**Harbourside Shopping Centre Redevelopment - Darling Drive, Darling Harbour
(SSD-49295711-Mod-2)**

Thank you for your correspondence via the Major Projects Portal on 2 September 2024, requesting Transport for NSW (TfNSW) to review and comment on the above.

Expansion of land uses on level 1

Figure 1: Promenade Indoor and Outdoor Dining and L1 Event Use – Day and Evening

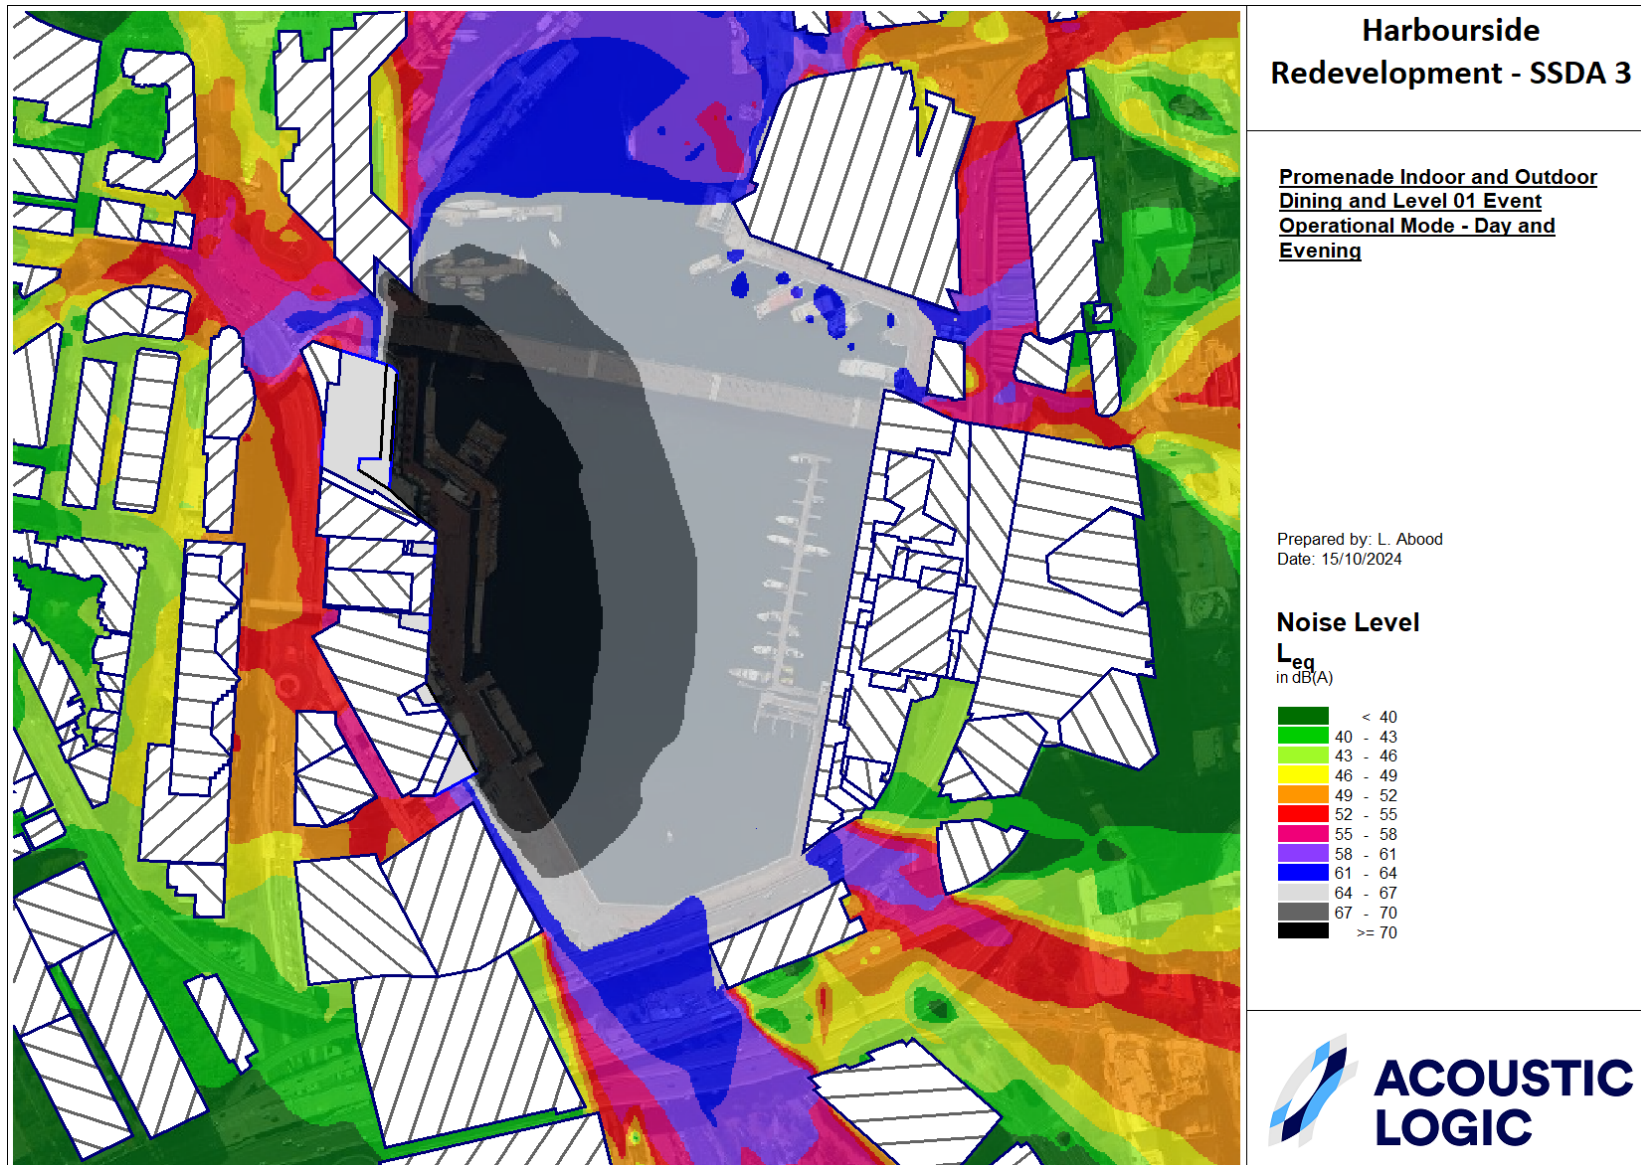
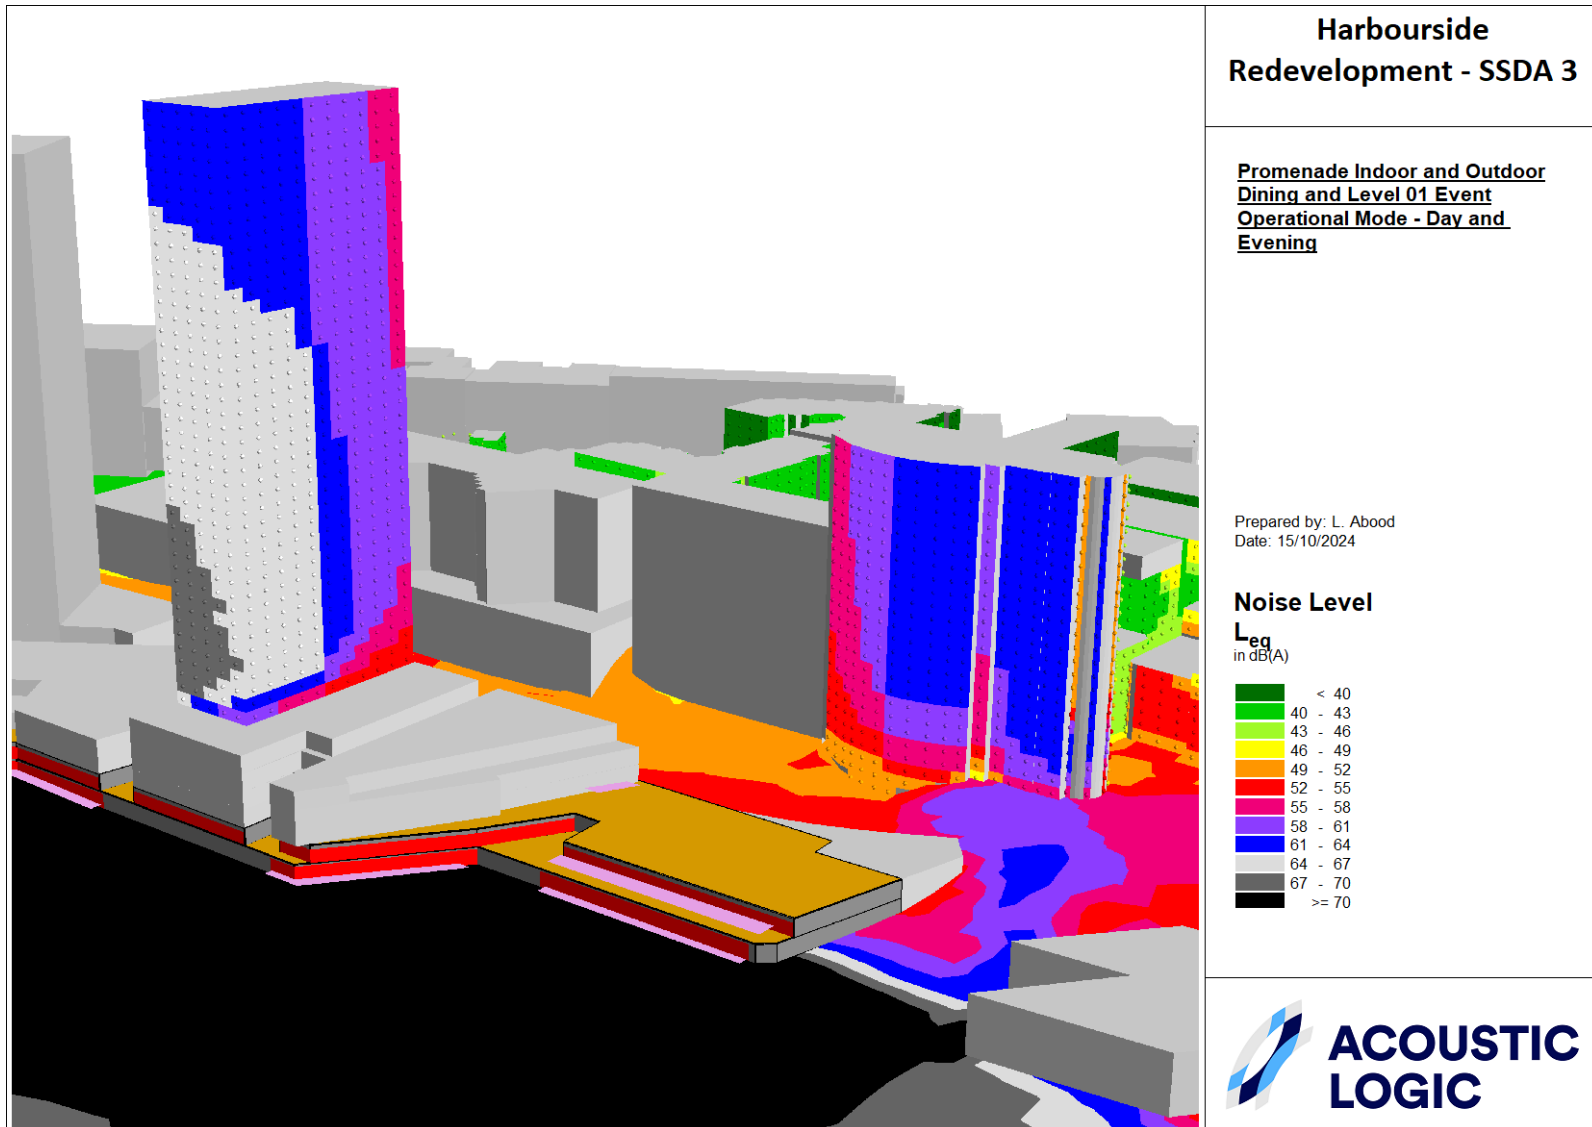
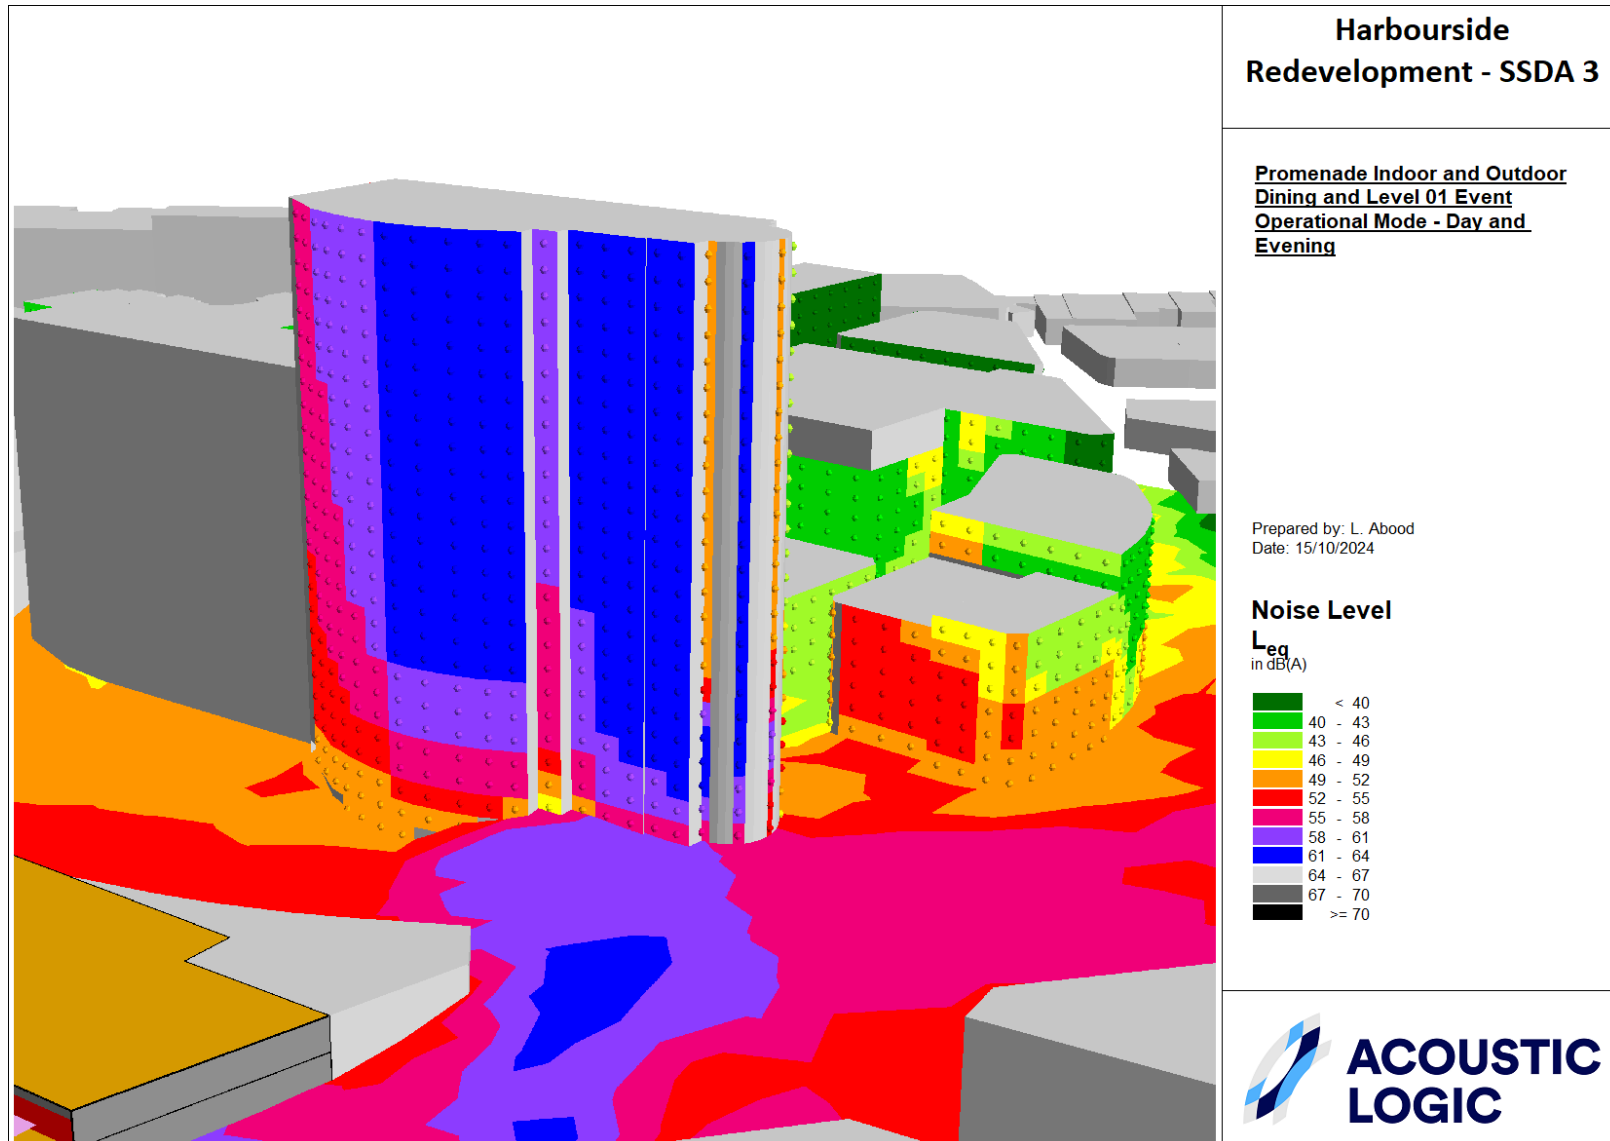
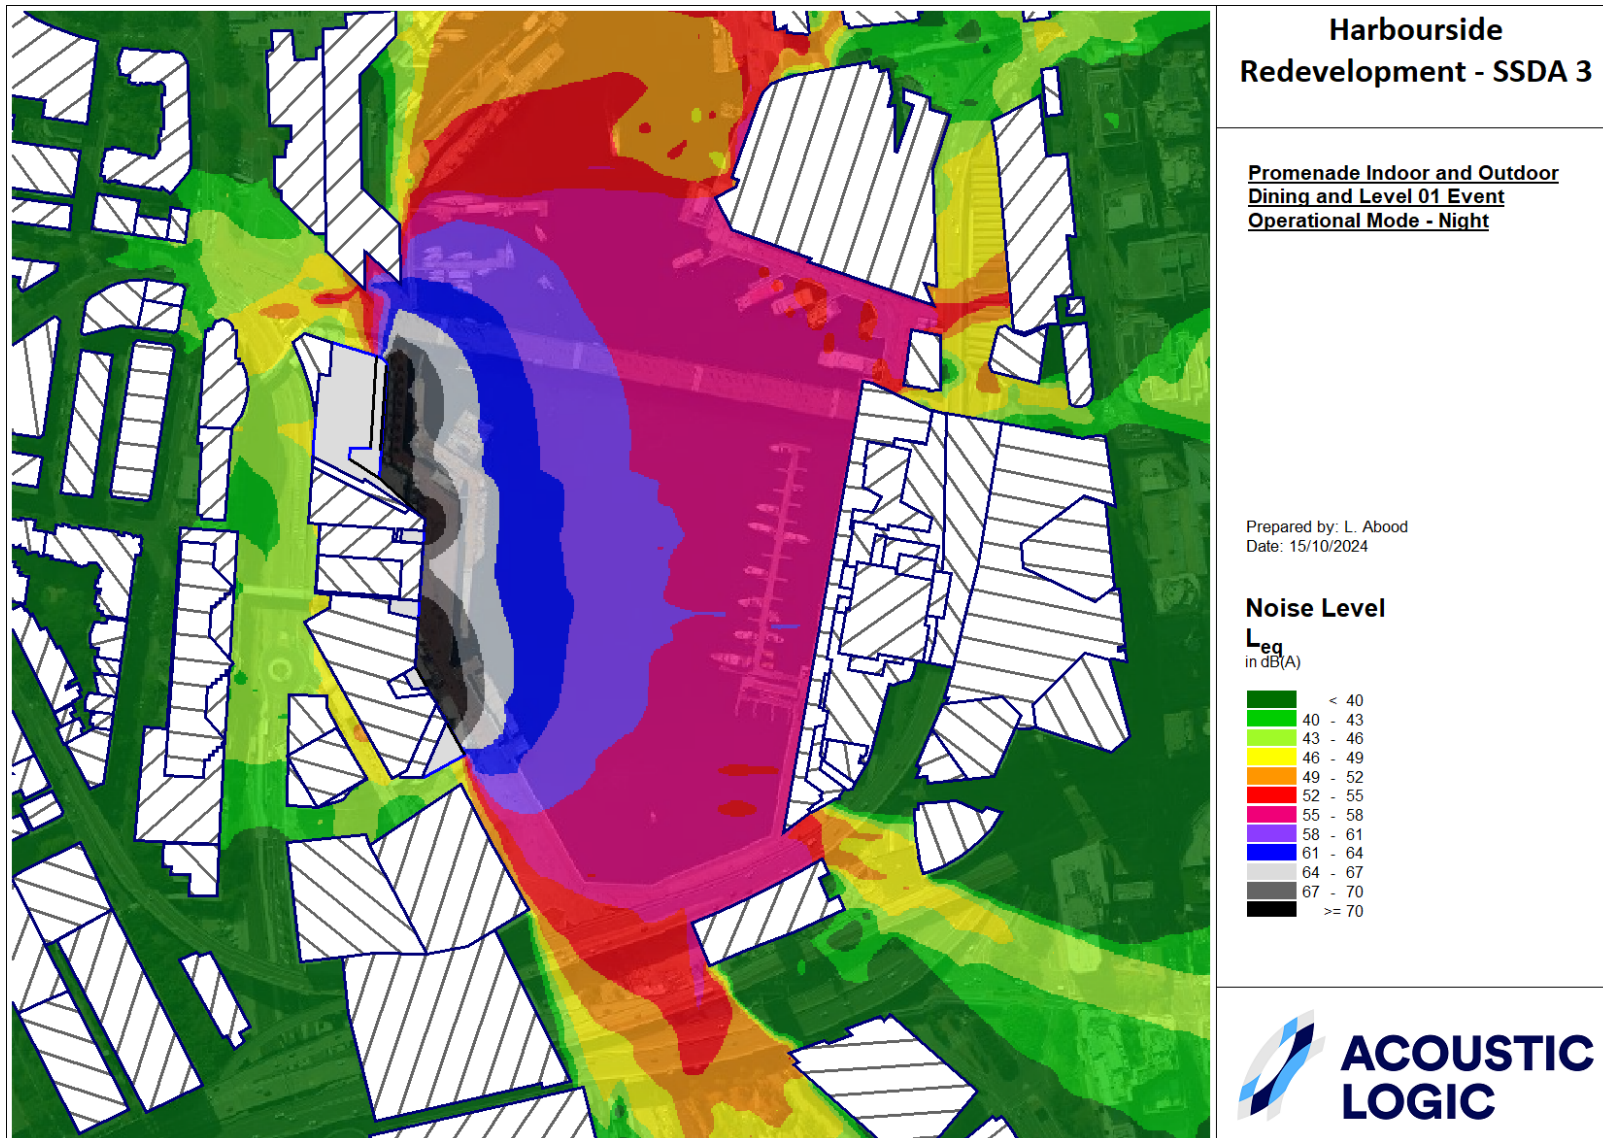
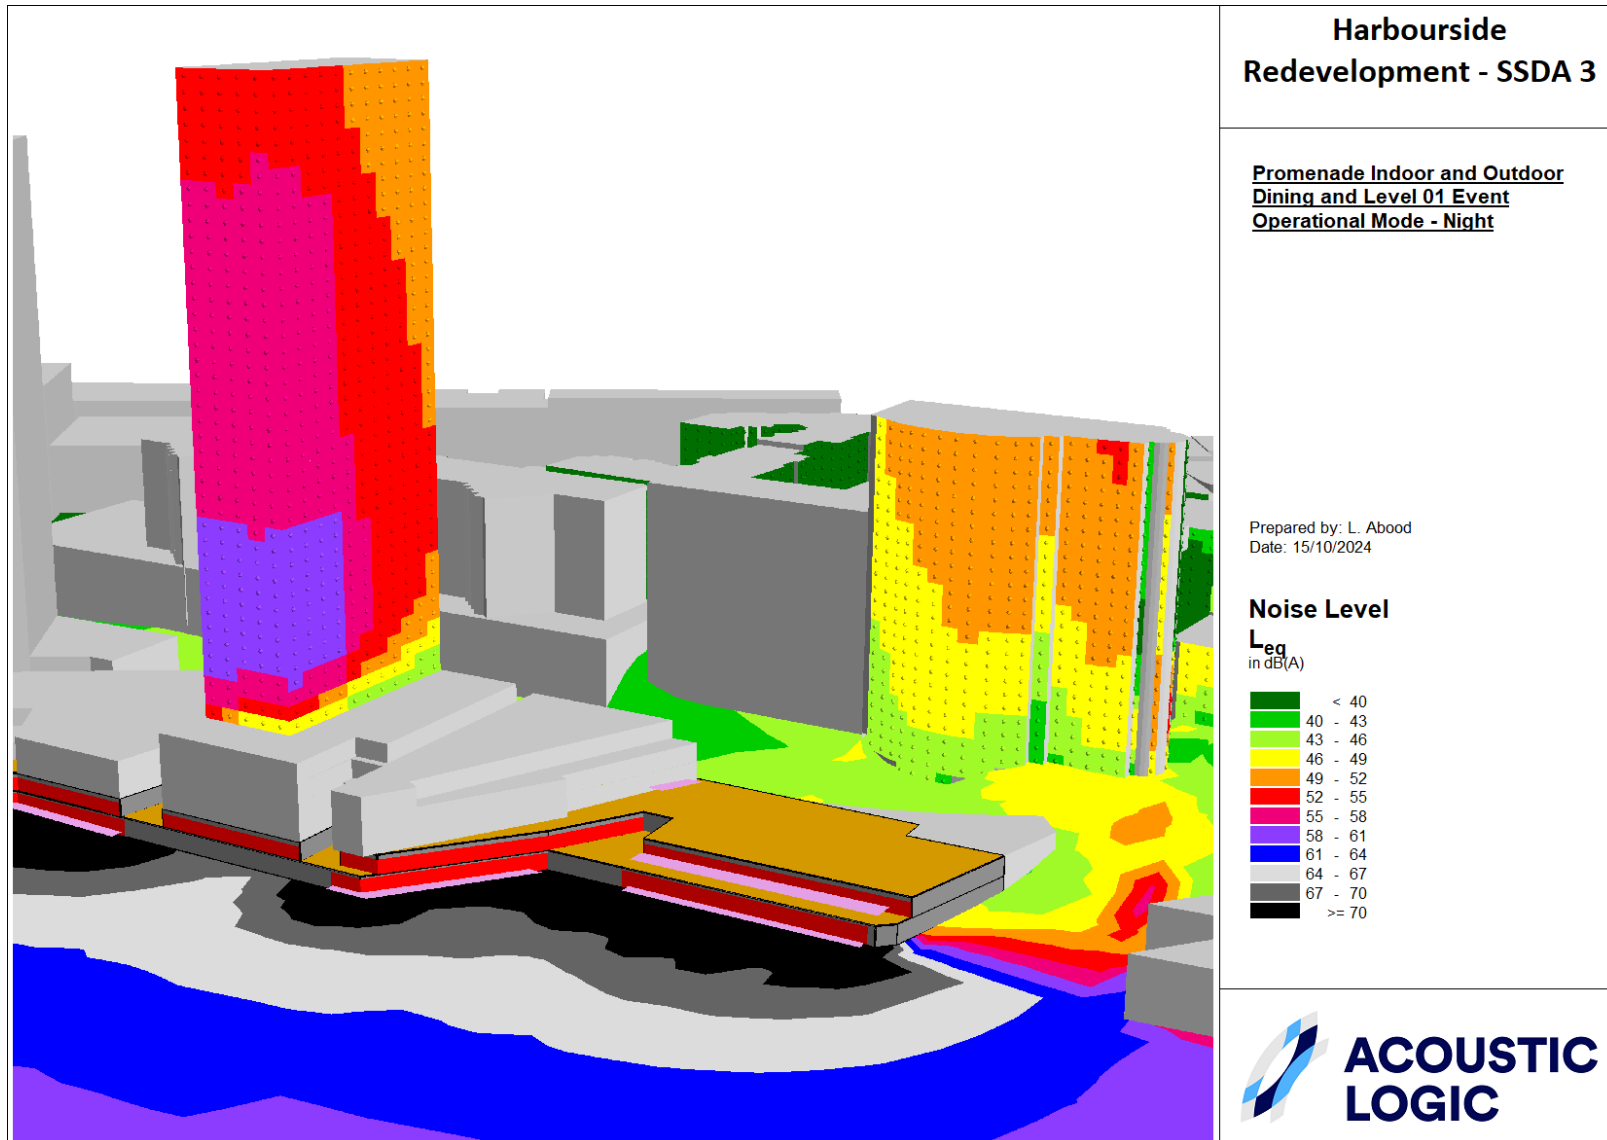
The above modification proposes expansion of land uses to include event and conference uses for the commercial component of the development. The Transport Assessment Report prepared to support the modification proposal states that:

- 37% of patrons accessing the event / conference space would use point to point transport; and
- Typical events and conferences of a business or corporate nature typically occur during working hours, and thus patrons are unlikely to be travelling on the road network during the commuter peak hours.

- Drop-off and pick-up movements from other users within the building and the Precinct need to be included for the travel mode study; and
- Patrons attending events and conferences during working hours would have the potential to arrive / depart the site during the commuter peak periods.

It is requested that the applicant demonstrates as part of the Response to Submissions that the drop off / pick-up area will have adequate capacity to accommodate the additional demand likely to generated by the proposed event and conference uses, taking into consideration the commuter peak as well as other concurrent events within the precinct.
